KITTITAS COUNTY

MEMORANDUM

TO: All Staff
FROM: Public Works Plan Review Team
DATE: July 25, 2022
SUBJECT: BL-22-00015 Defoor

The Public Works Department has reviewed the Request for Boundary Line Adjustment Application.

DEFOOR BLA SITE PLAN

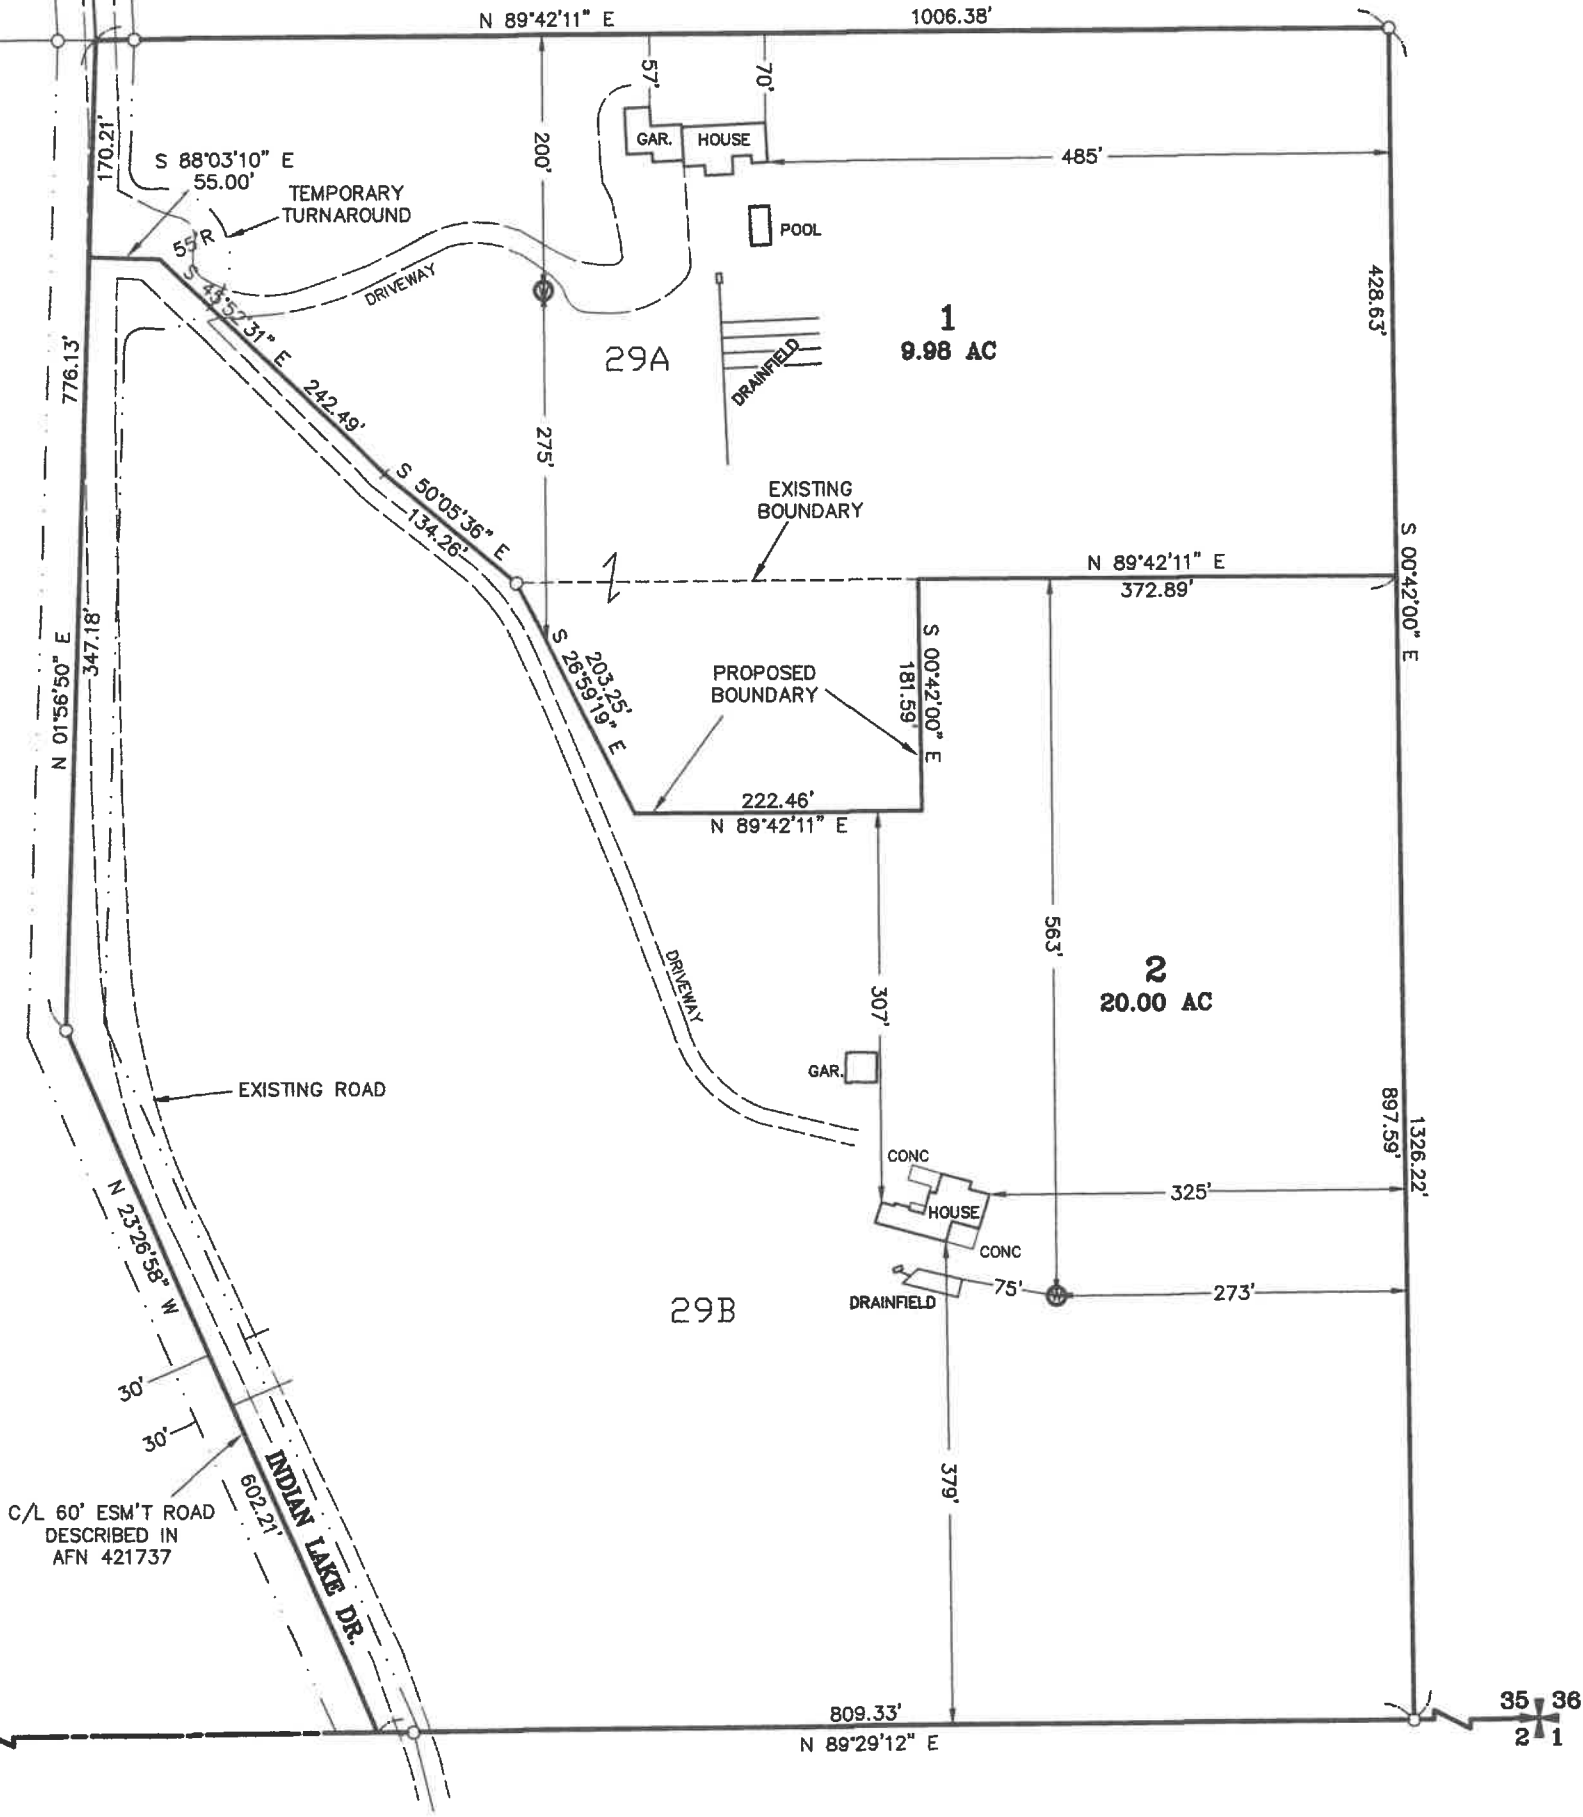
- 4.) Driveway on parcel 29B comes close to new proposed boundary line of parcel 29A. Applicant should be aware that no driveway or road shall be constructed within five feet of the side yard boundary, unless the driveway or road is part of an easement shared with the neighboring property owner (KCC 12.05.080).
